**Christian Brothers Automotive**  
Lot 2, Woodmen Hills Filing No. 7J  
Highway 24 at E Woodmen Road  
Falcon, County of El Paso, CO

Date	
Revisions	
2/2/18 - Issued for Site Plan Review	
Project No.	17-37
Drawn By:	
Date:	2/2/18
Sheet Title:	
<b>SITE PHOTOMETRIC PLAN</b>	
Drawing No.	<b>A-4.1</b>
RH10N-10-2017

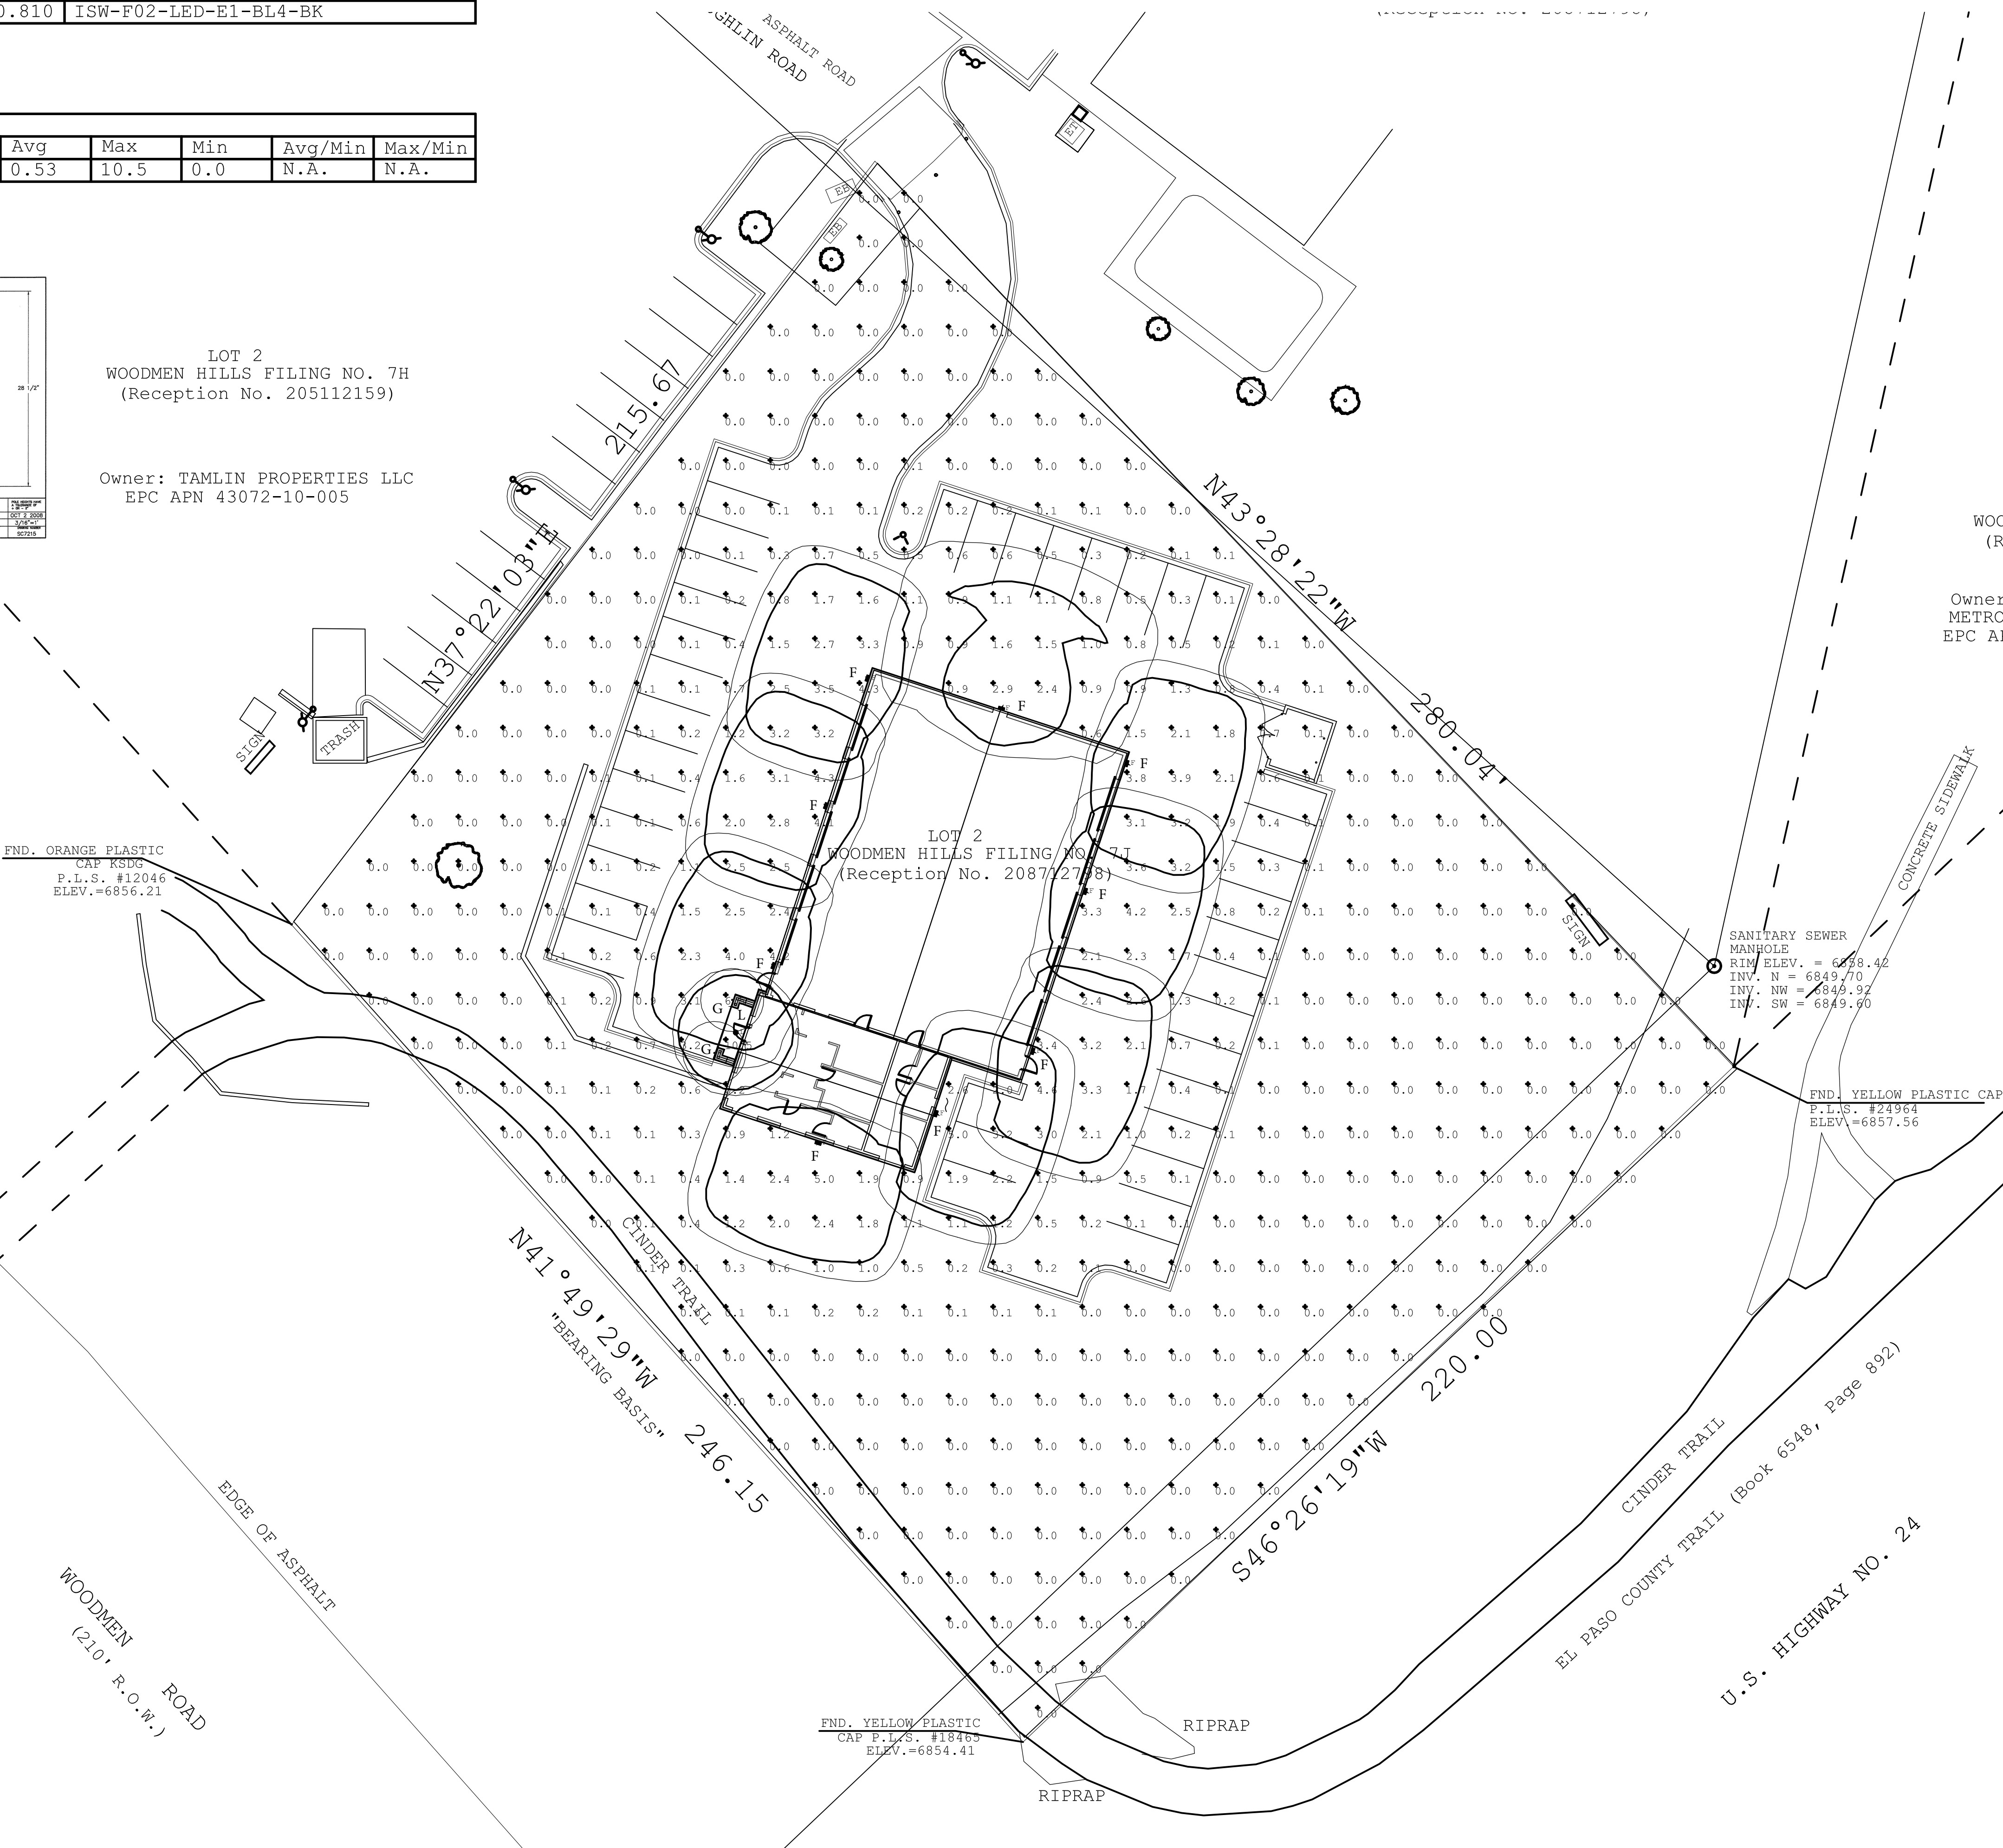
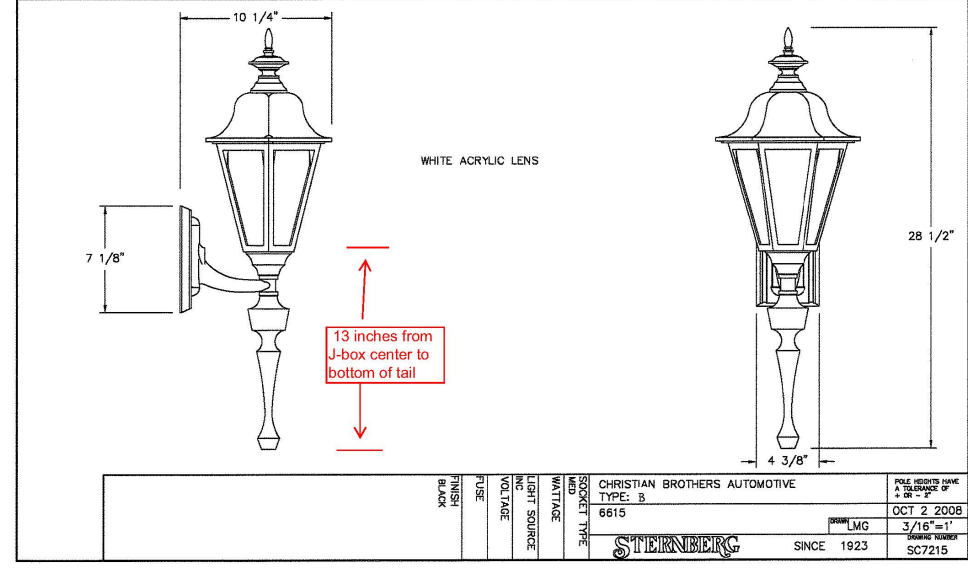
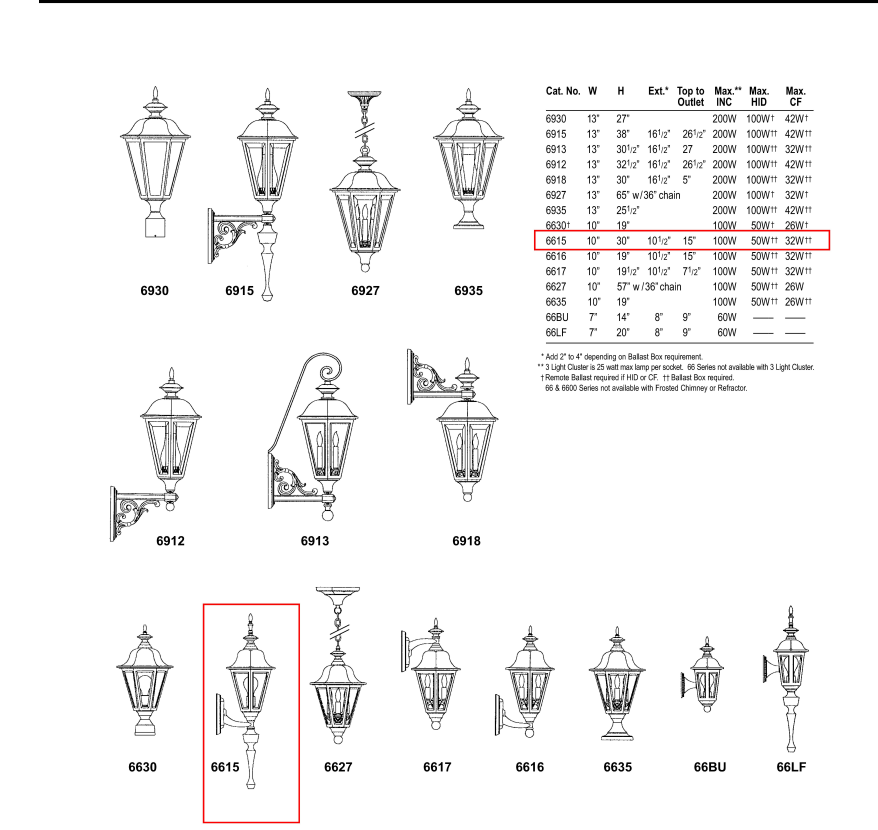
What is this depicting? Are there no parking lighting proposed?
